From: Laura Gibbons <Laura.Gibbons@arun.gov.uk>
Sent: 05 April 2022 11:13
To: Planning.Responses <Planning.Responses@arun.gov.uk>
Cc: David Easton <David.Easton@arun.gov.uk>
Subject: RE: Planning Consultation on: Y/33/22/DOC

Engineers Comments Regarding Condition 9

Description of Works: Approval of details reserved by condition imposed under ref Y/91/17/OUT relating to Condition No 9 - surface water drainage.

BASIN 4 SECTION G-G
SCALE: H 1:500,V 1:100. DATUM: 2.000

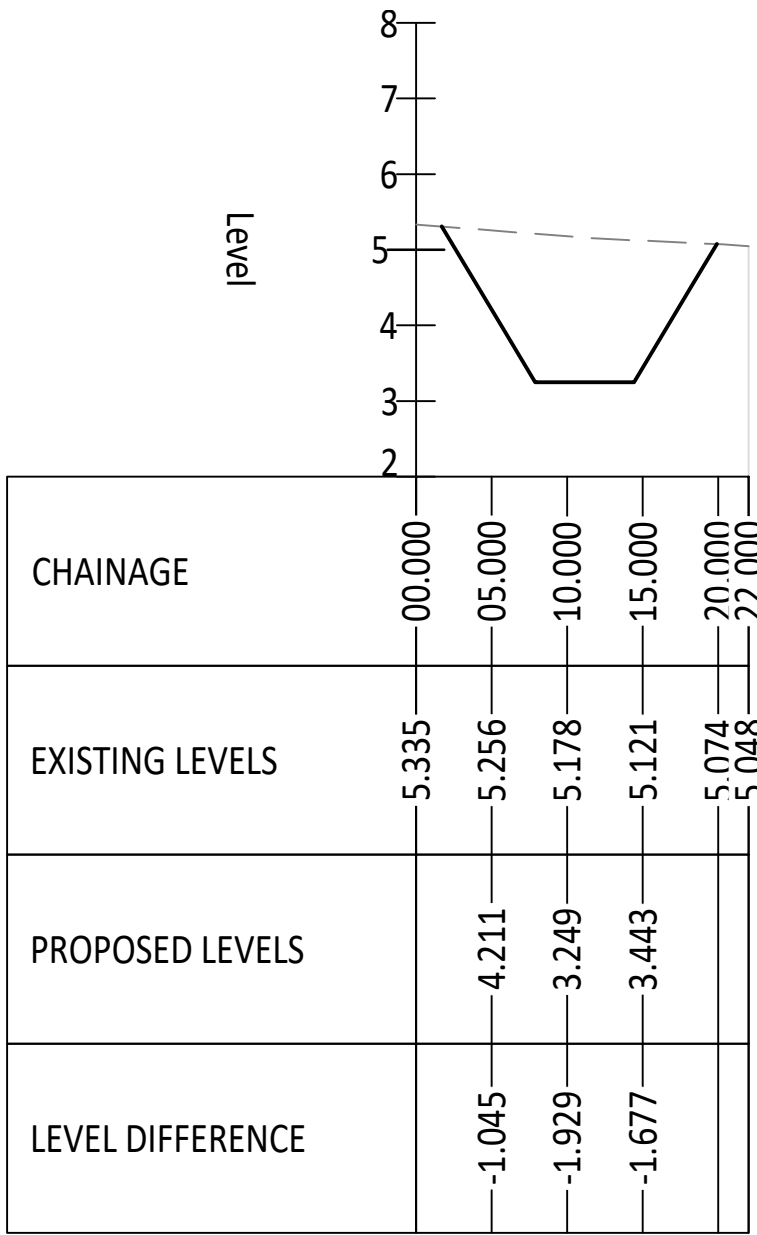
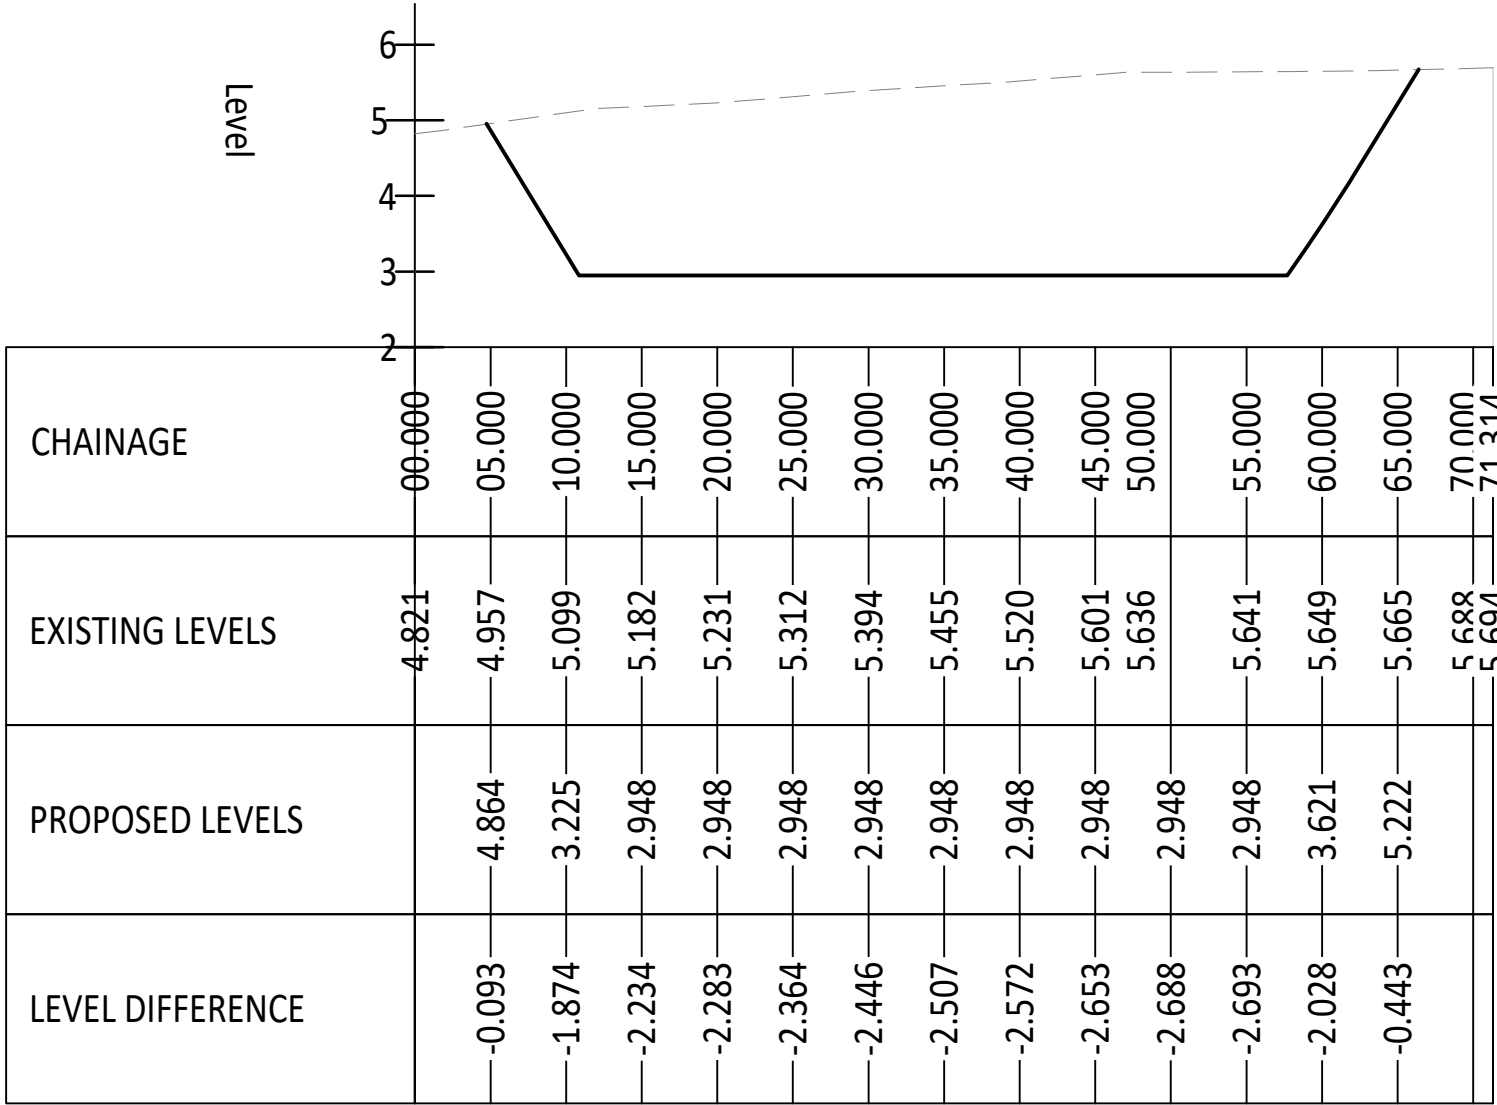
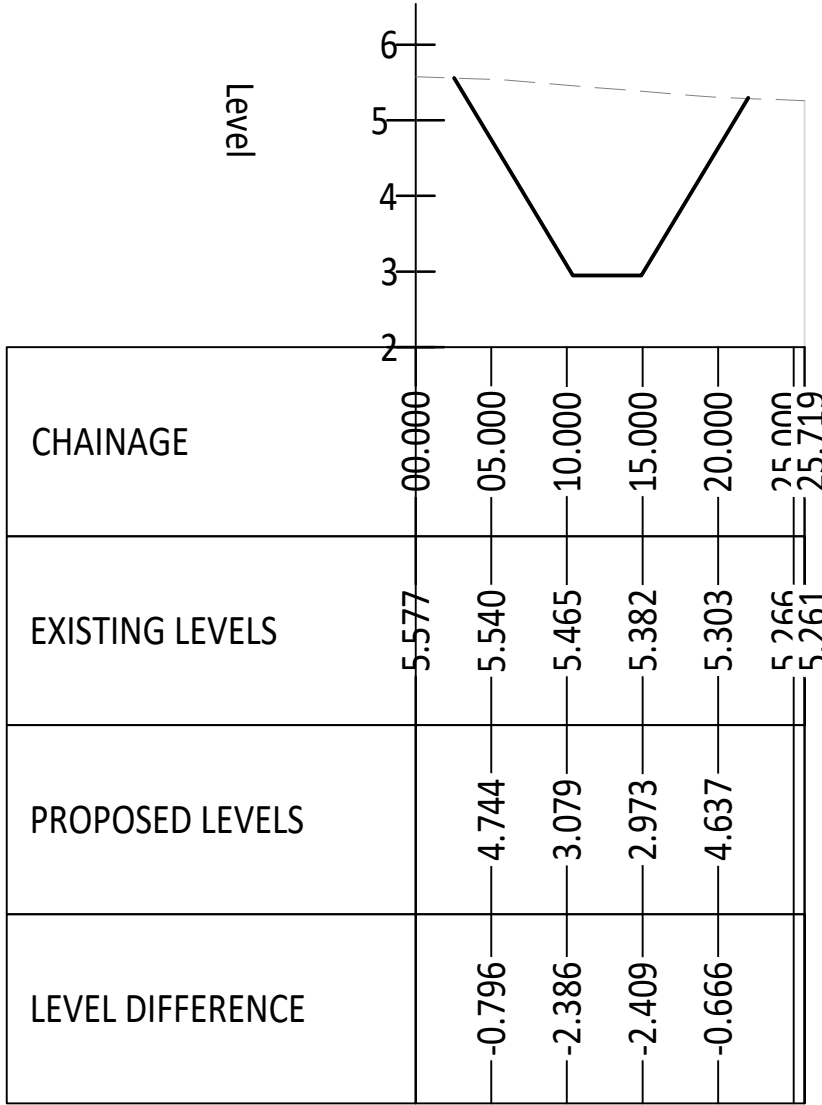
24. Please provide construction detail drawings of basins which clearly show required depths of topsoil and clay over liner which tally with flotation calculations. These details should show invert level, peak water level, and top of bank level of each basin, along with bank slope. Two perpendicular details per basin should be provided.

HEADWALL PLAN (S60 & S111)
(1:20)

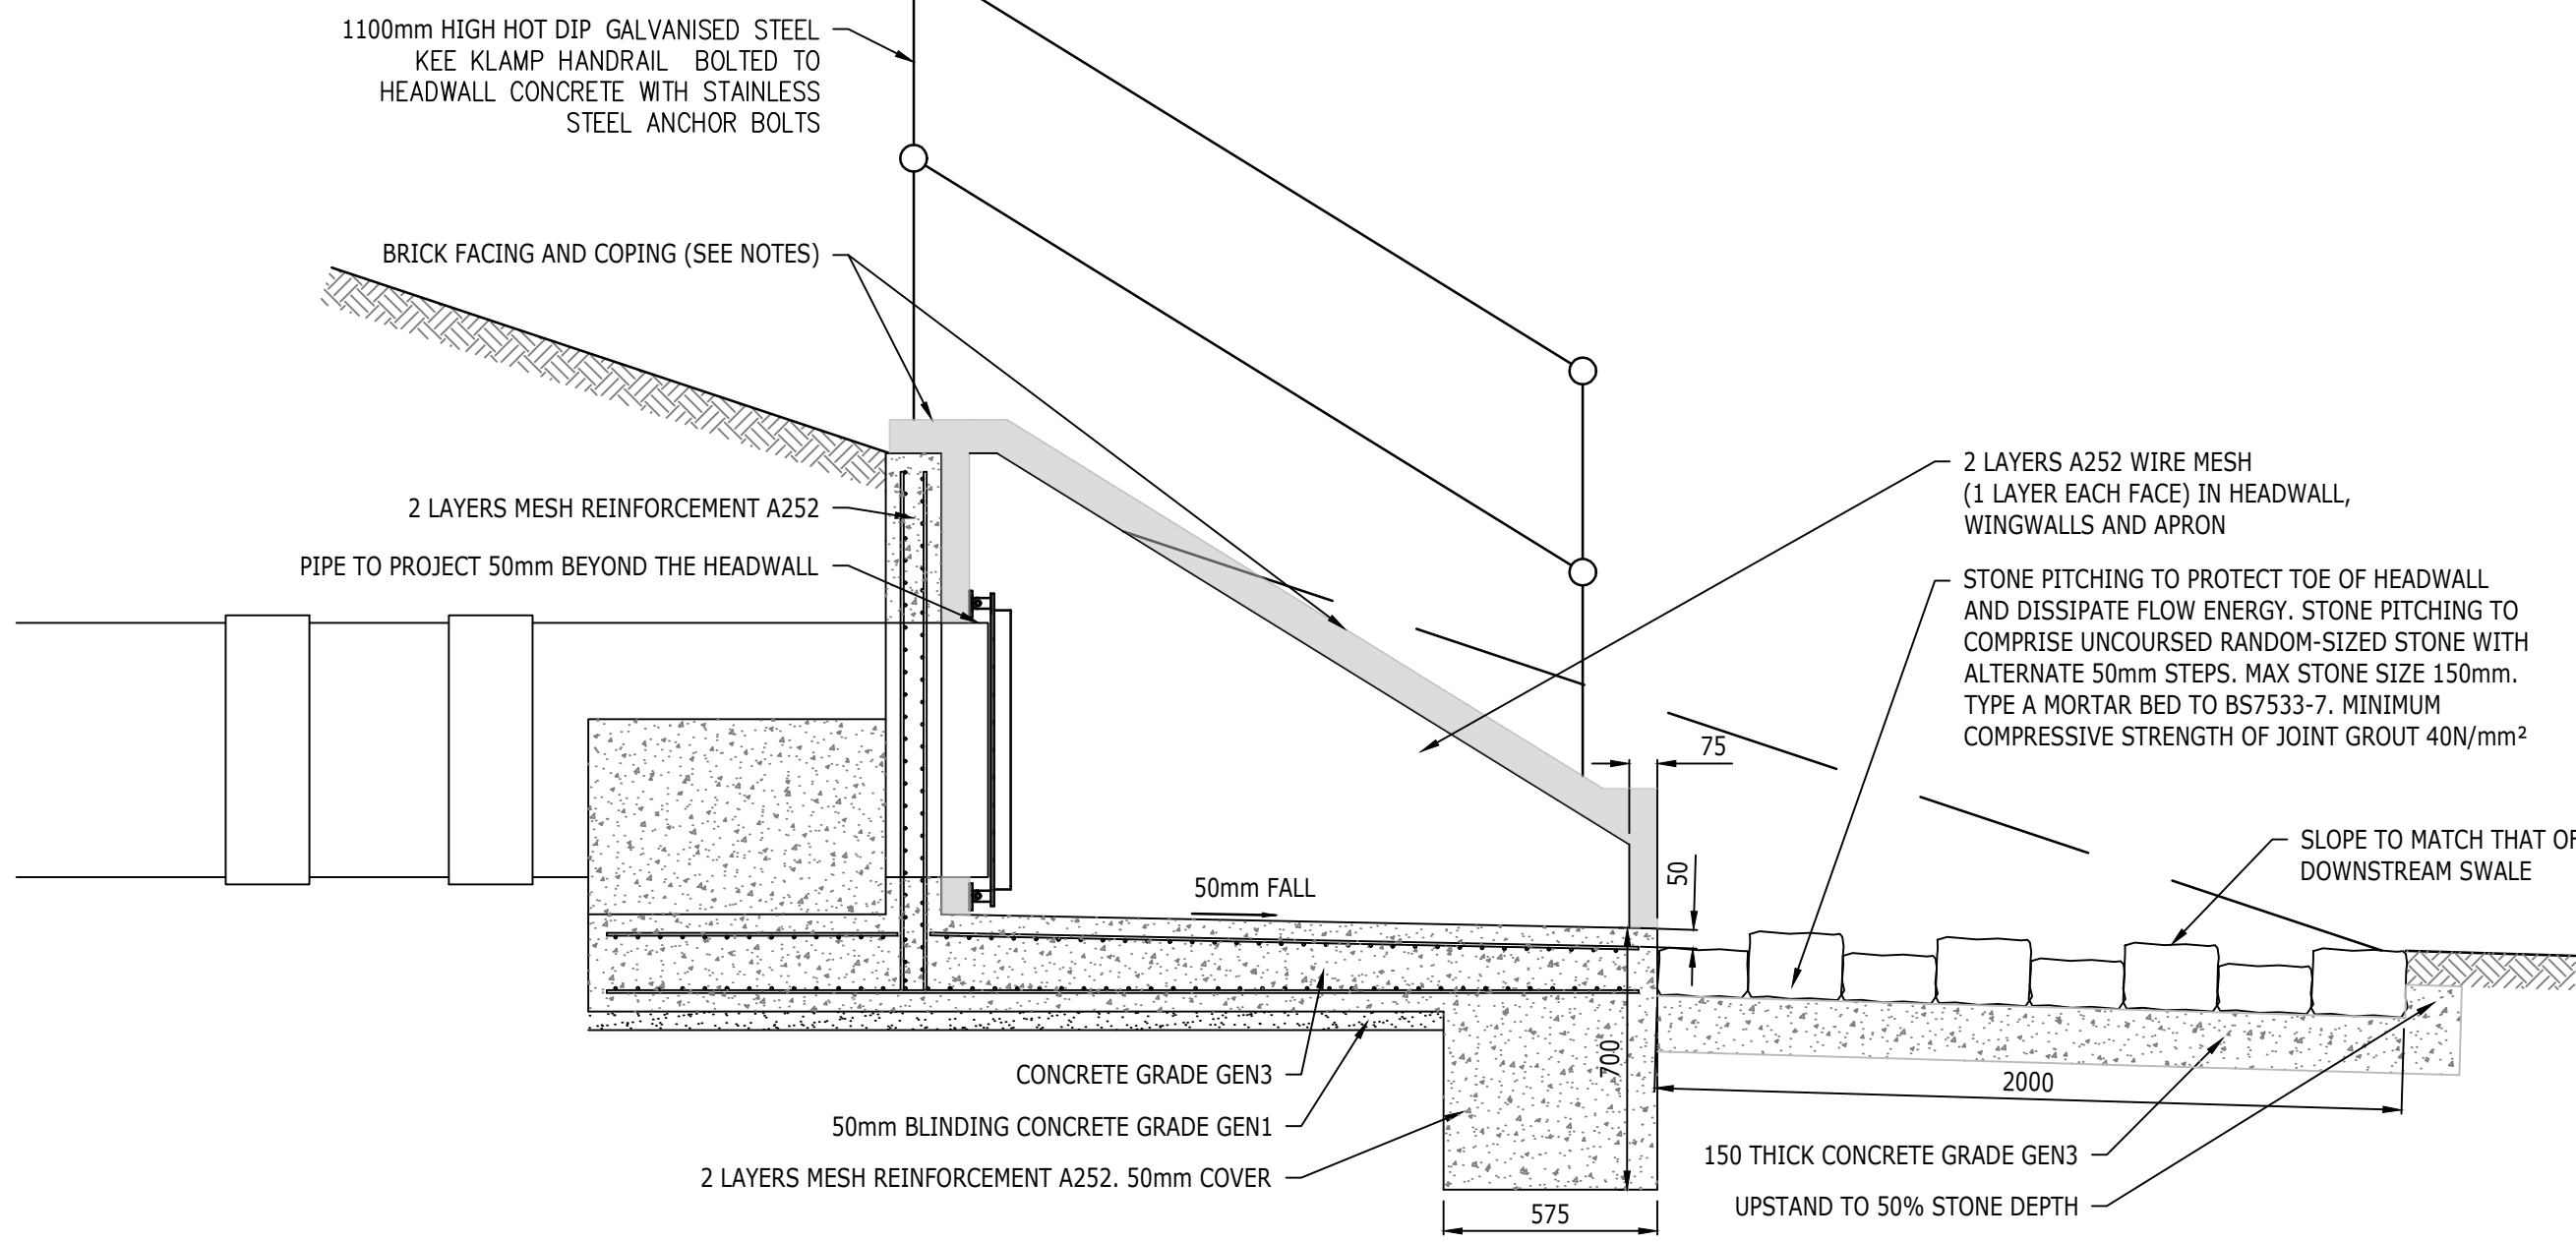
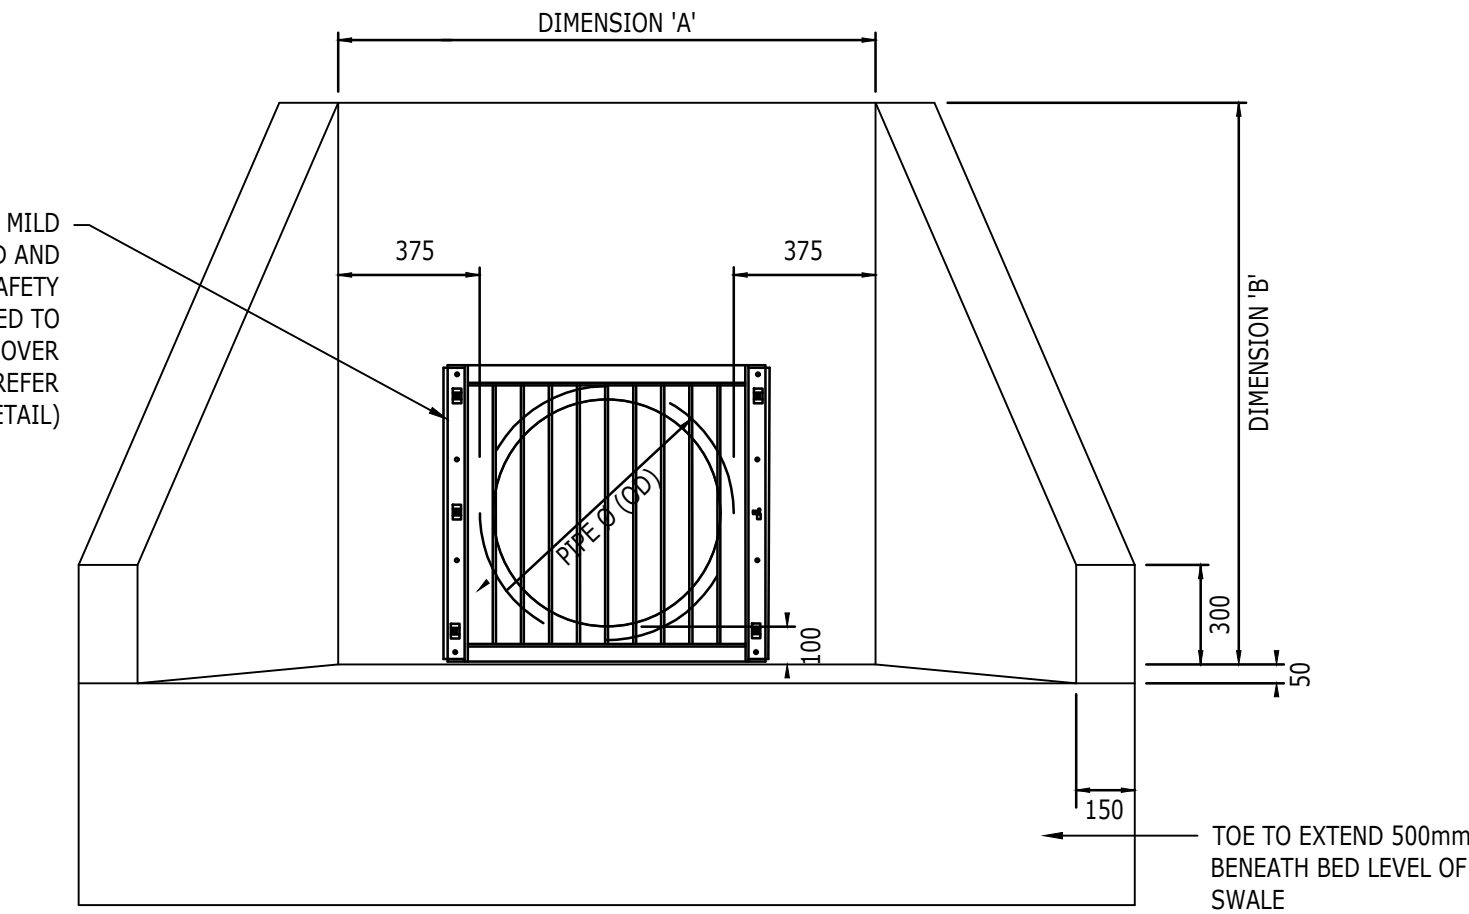
11. Please provide cranked grilles at a 45 degree angle.
12. Please detail invert levels of hydrobrakes and invert levels of overflows for each flow control device on the detail drawing.
